City of Portland, Maine - Building or Use Permit Application
 389 Congress Street, 04101 Tel: (207) 874-8703, Fax: (207) 874-8716

Permit No: 02-0655	Issue Date: []	CBL: 335 G011001
-----------------------	--------------------	---------------------

Past Use: Vacant	Proposed Use: Single Family / New 71' x 40' single family with 24' x 22' attached garage.	Permit Fee: \$973.00	Cost of Work: \$125,000.00	CEO District: 1
Proposed Project Description: Build New 71' x 40 Single Family w/ 24' x 22' Attached Garage <i>NO rear deck</i>		FIRE DEPT: <input type="checkbox"/> Approved <input type="checkbox"/> Denied	INSPECTION: Use Group: R3 Type: SB <i>SP/3/02</i>	
		Signature:	Signature: <i>[Signature]</i>	
PEDESTRIAN ACTIVITIES DISTRICT (P.A.D.)				
Action: <input type="checkbox"/> Approved <input type="checkbox"/> Approved w/Conditions <input type="checkbox"/> Denied				
		Signature:	Date:

Application ID Number: 2-0655

PLAN SHOWING A  
PROPOSED BUILDING LOCATION  
MADE FOR  
**ROBERT P. BURKHARDT**  
OF LAND LOCATED AT  
HASKELL STREET, PORTLAND, MAINE  
SCALE: 1/4" INCH = 30 FEET, JUNE 1, 2002  
COMPILED BY:  
WILLIAM G. AUSTIN, PLS 2174  
82 ELDERBERRY LANE  
NEW GLOUCESTER, MAINE 04260  
(207) 632-2959

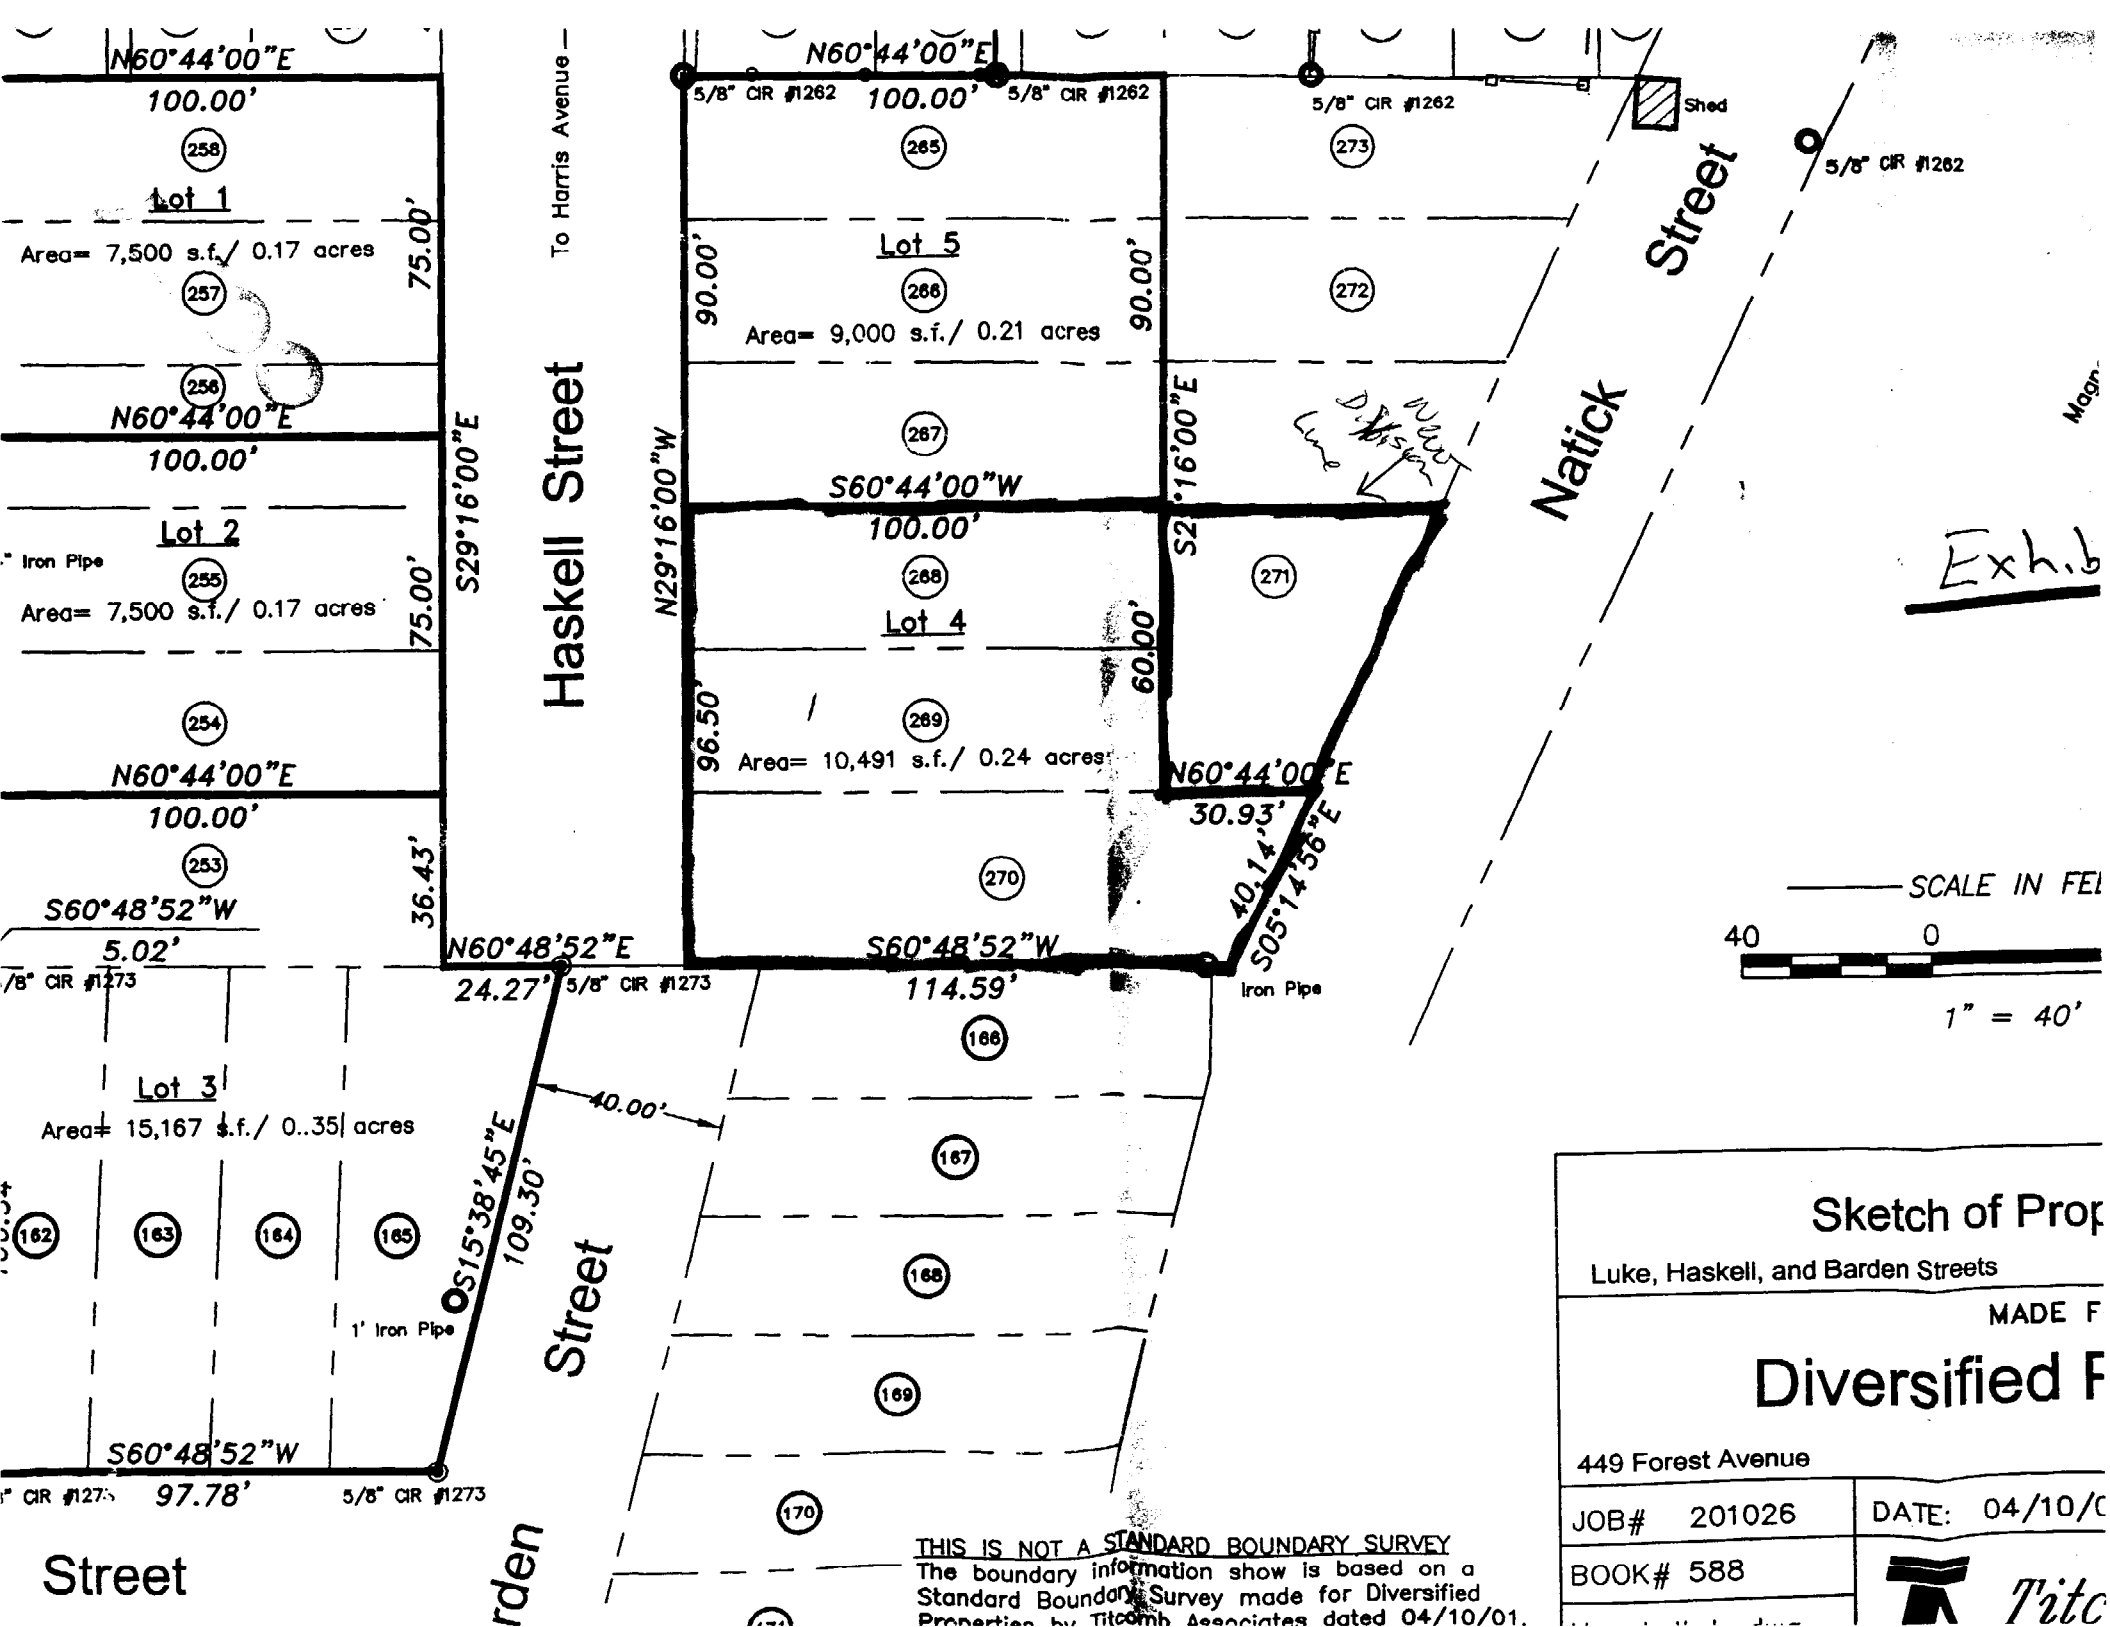
Comments: 20 Haskell St
Confusing permit with two different plot plans attached. - I finally determined the correct one - too close to lot lines and at least 100 sq. Ft. Over lot coverage requirements. - I put a call into the owner. - owner came in - the grade level has

This permit is being approved on the basis of plans submitted. These plans were changed by the owner while at the City counter in order to correct some zoning deficiencies. Any deviations shall require a separate approval before starting that work.

REAR ELEVATION

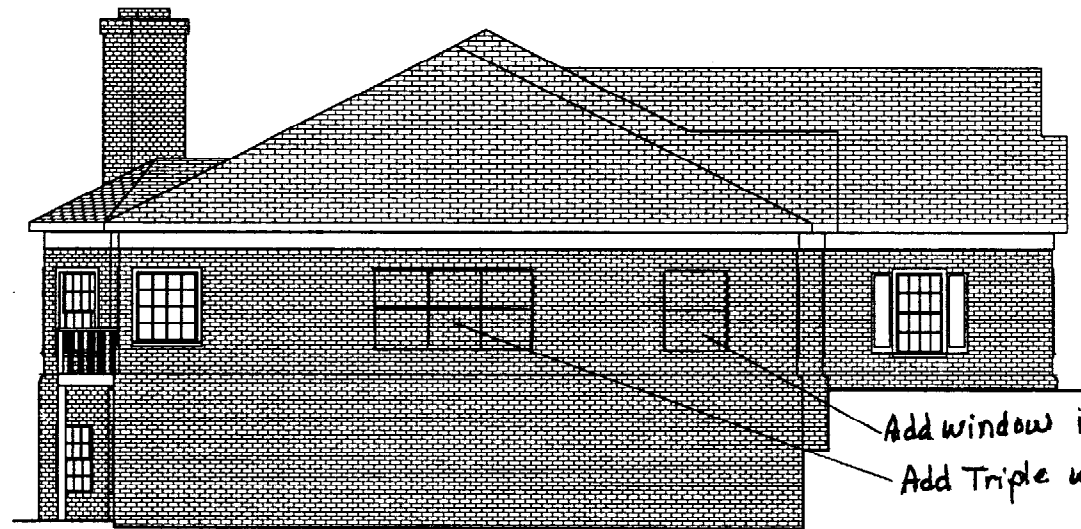
No rear Deck or Bulkhead on the side

It is understood that there will be no daylight basement and that less than half of the basement floor-to-ceiling height will be above grade. It is also understood that the rear deck will not be a built structure. It is also understood that the right hand side bulkhead will not be constructed.

Bob & Mary Burkhardt  
 20 Haskell Rd. Portland.  
 773-8736

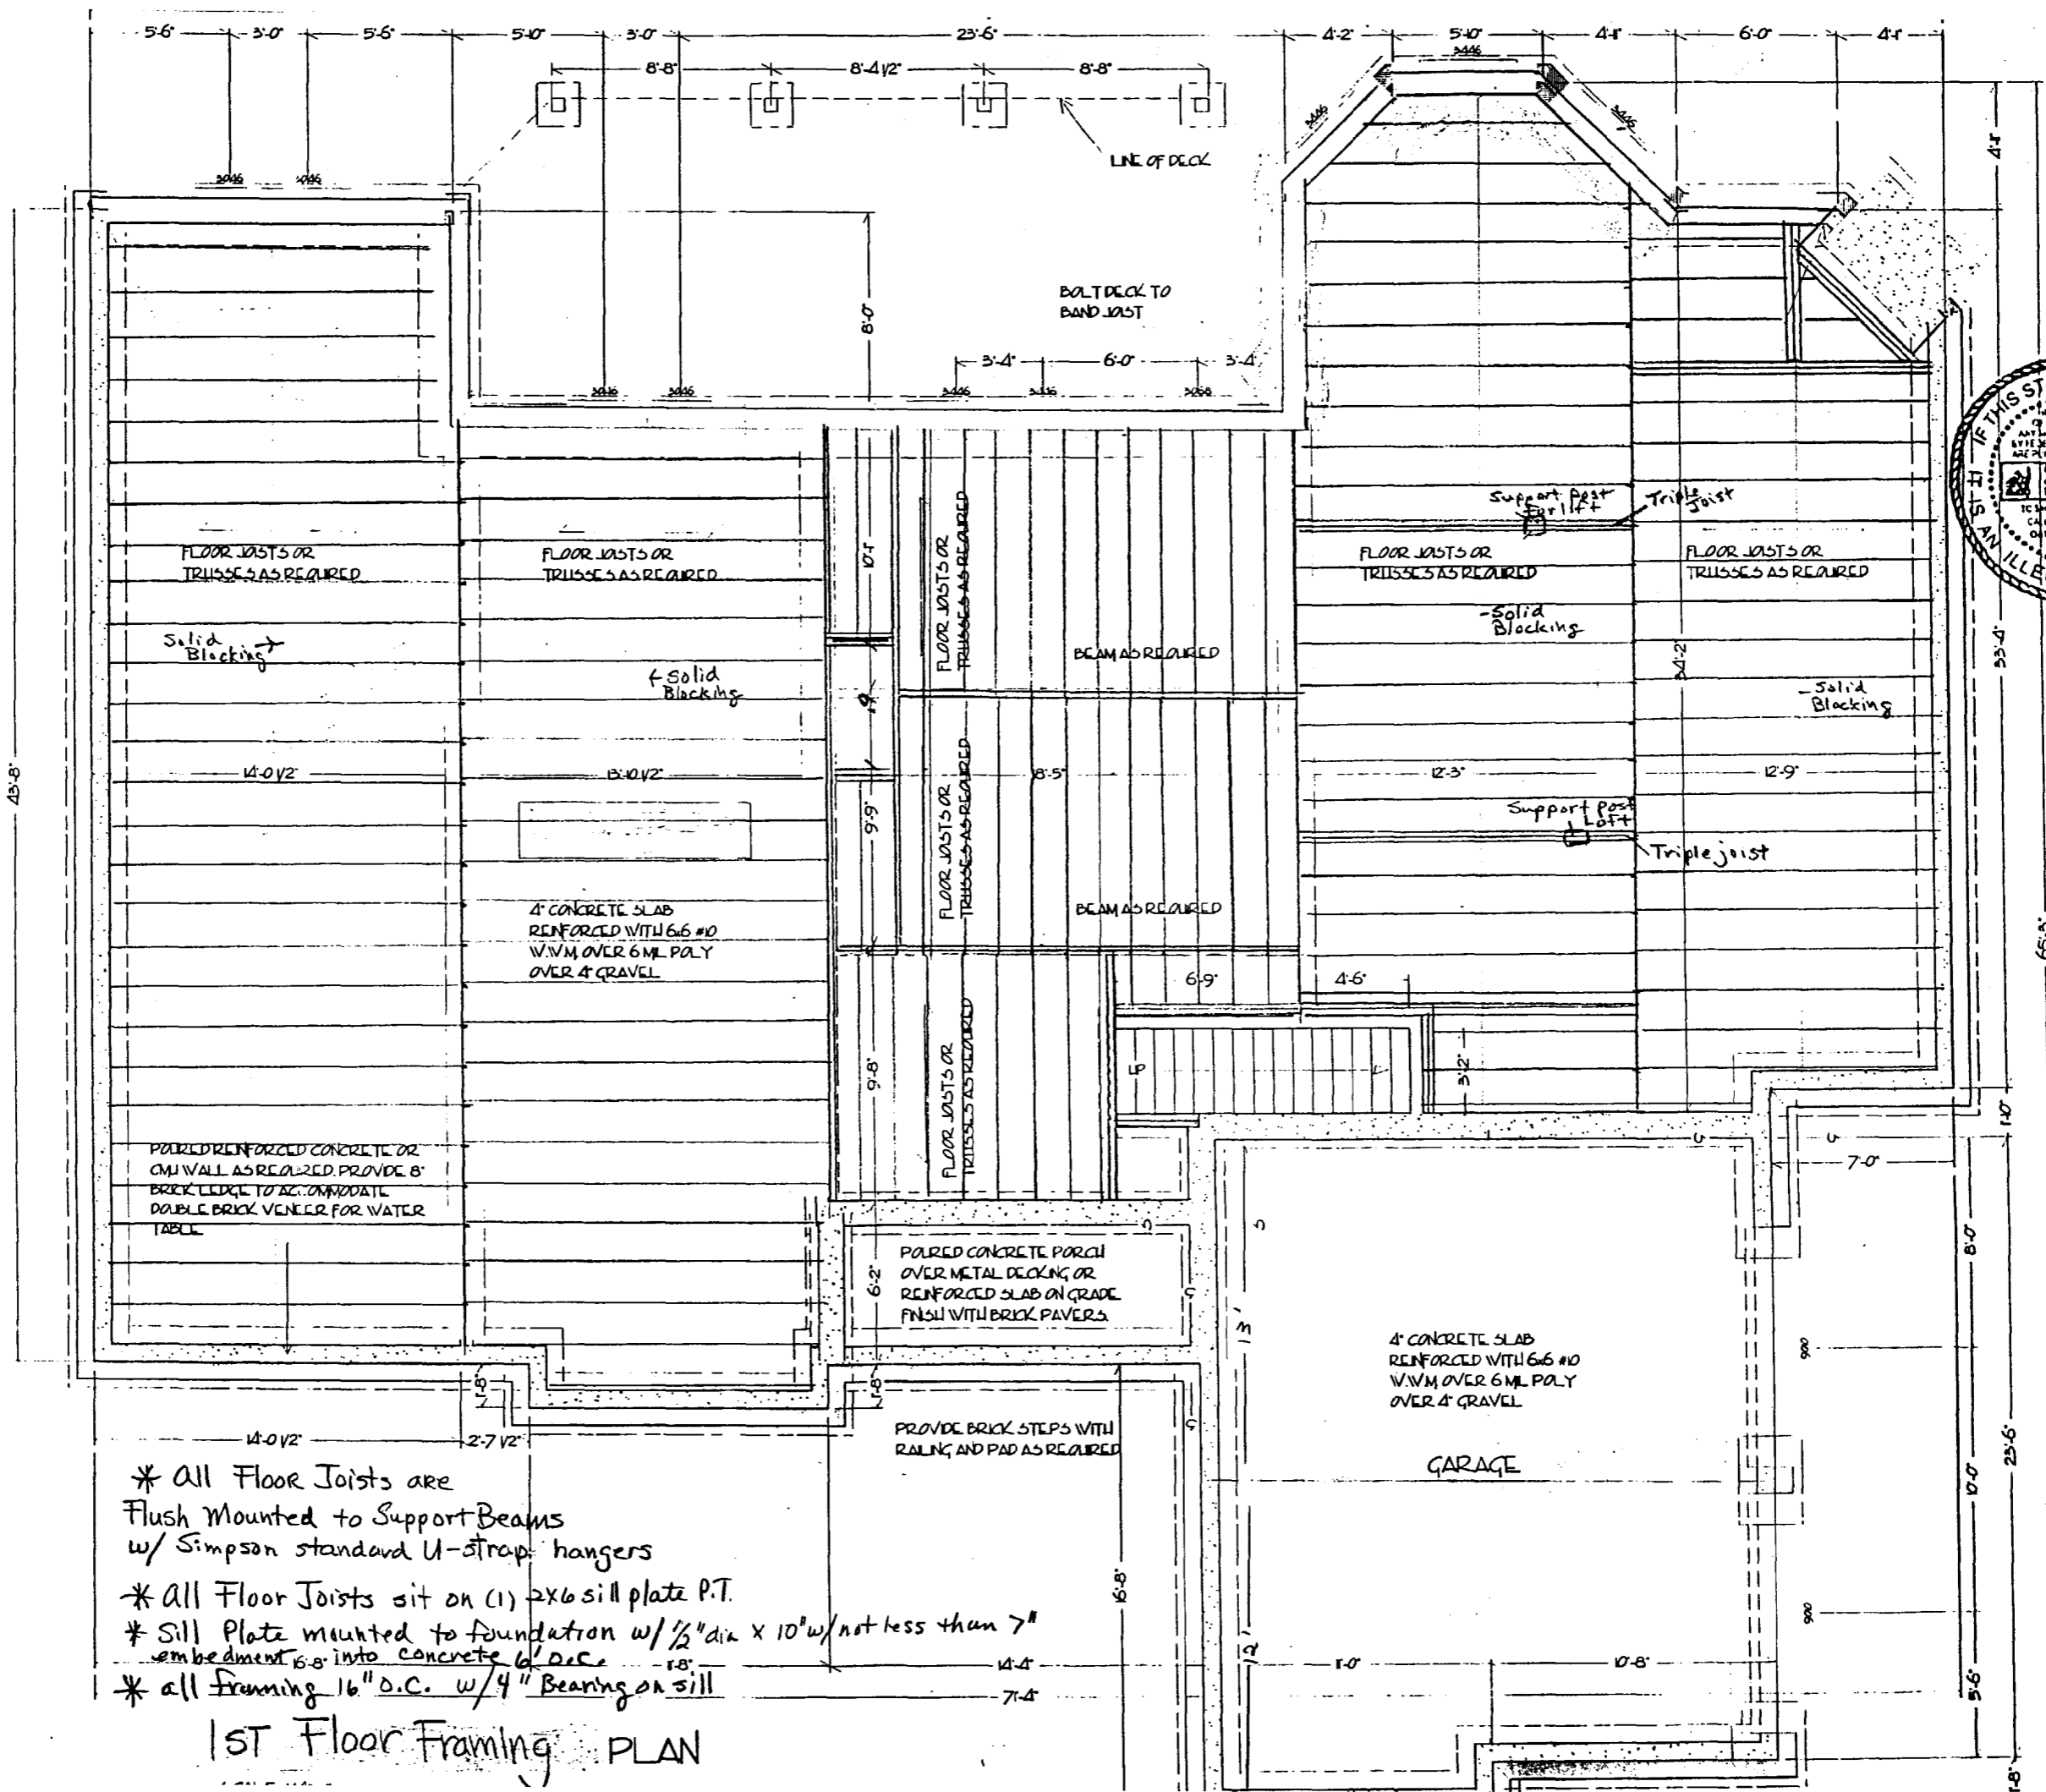
Girder design must be altered due to excessive spans, Foundation Only MJN

All girders to be THREE 1 3/4" x 11" LVL's all floor framing to be 2"x 10" -- 16" O.C. 8/12/02
